KITTITAS COUNTY COMMUNITY DEVELOPMENT SERVICES

RE: Transmittal of Comments – Red's Fly Shop Conditional Use Permit (CU-13-00003)

RED'S FLY SHOP CONDITIONAL USE PERMIT - CU-13-00003

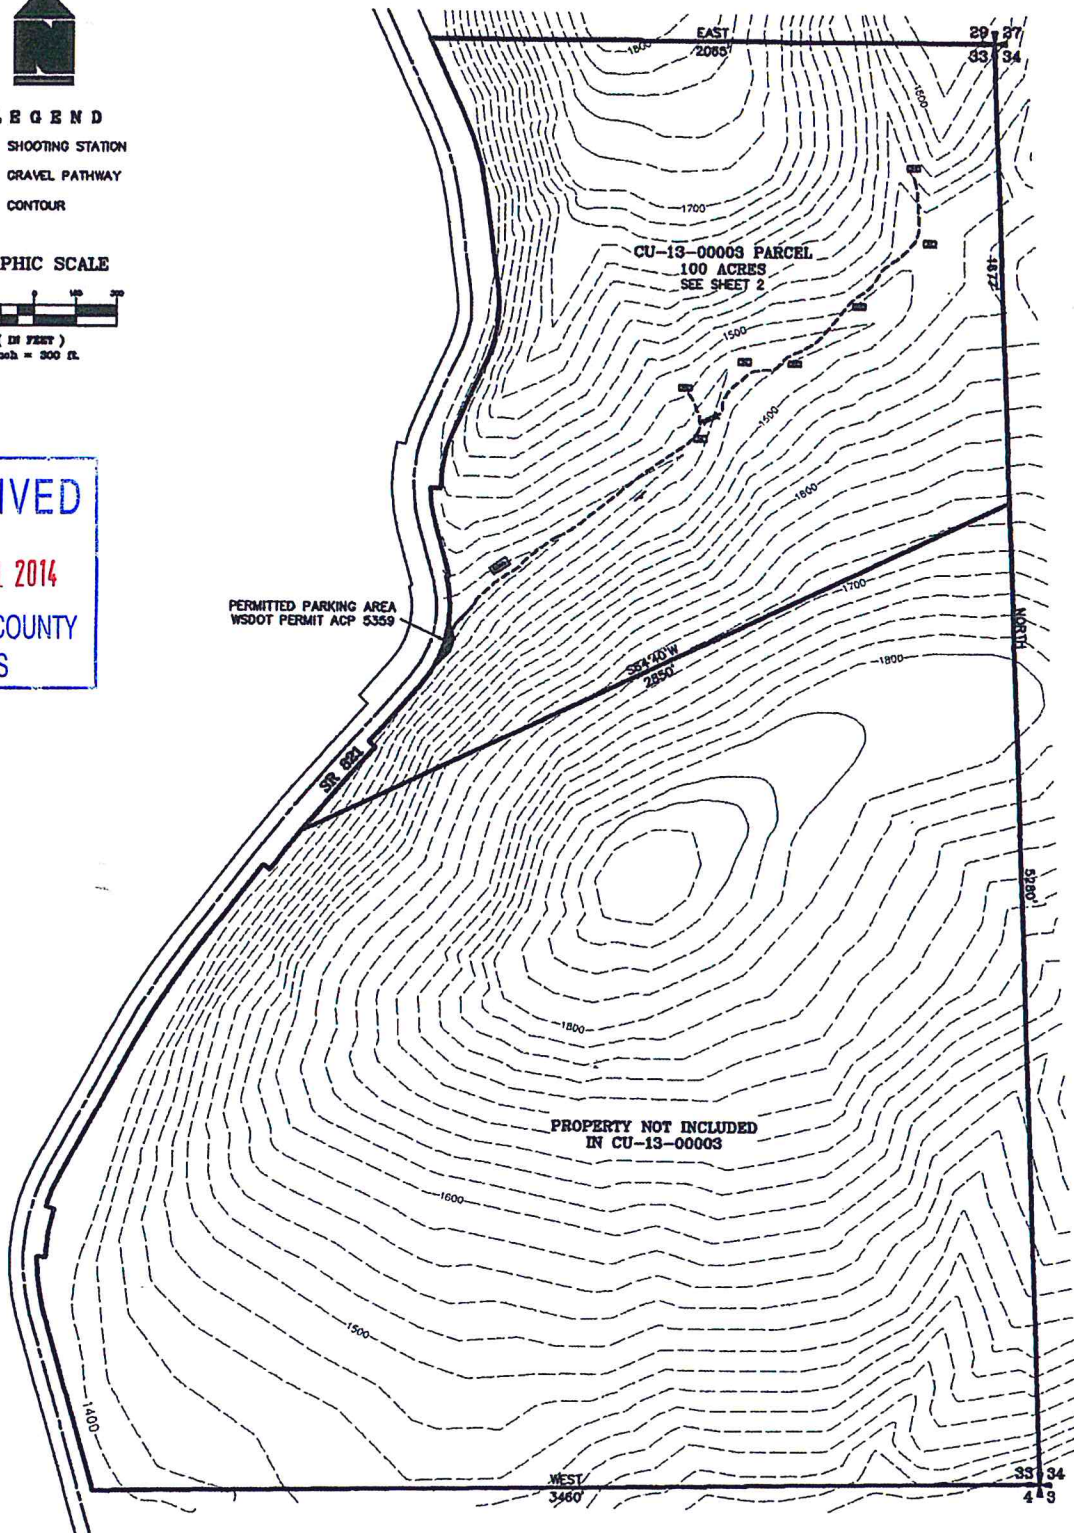
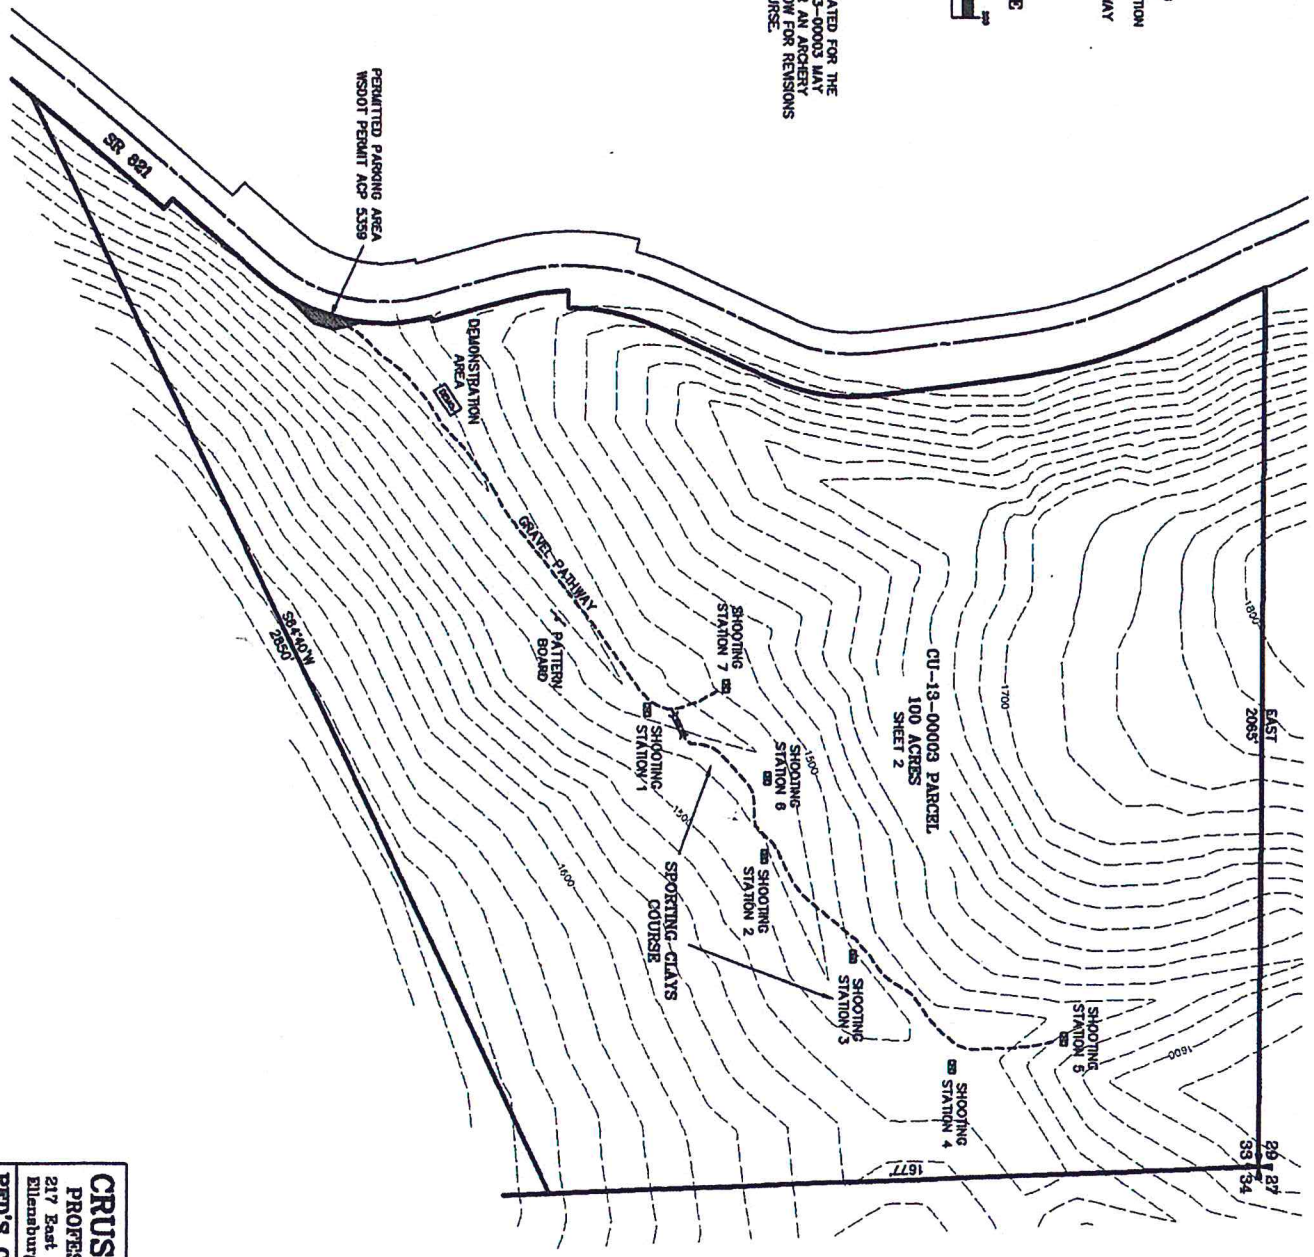
Lindsey, here is the WSDOT access permit that was noted on the drawings. A condition requiring them to comply with the WSDOT access permit conditions would probably be good.

The access permit allows three parking spaces, the application states 4-6. Beyond this, public works has no other comments.
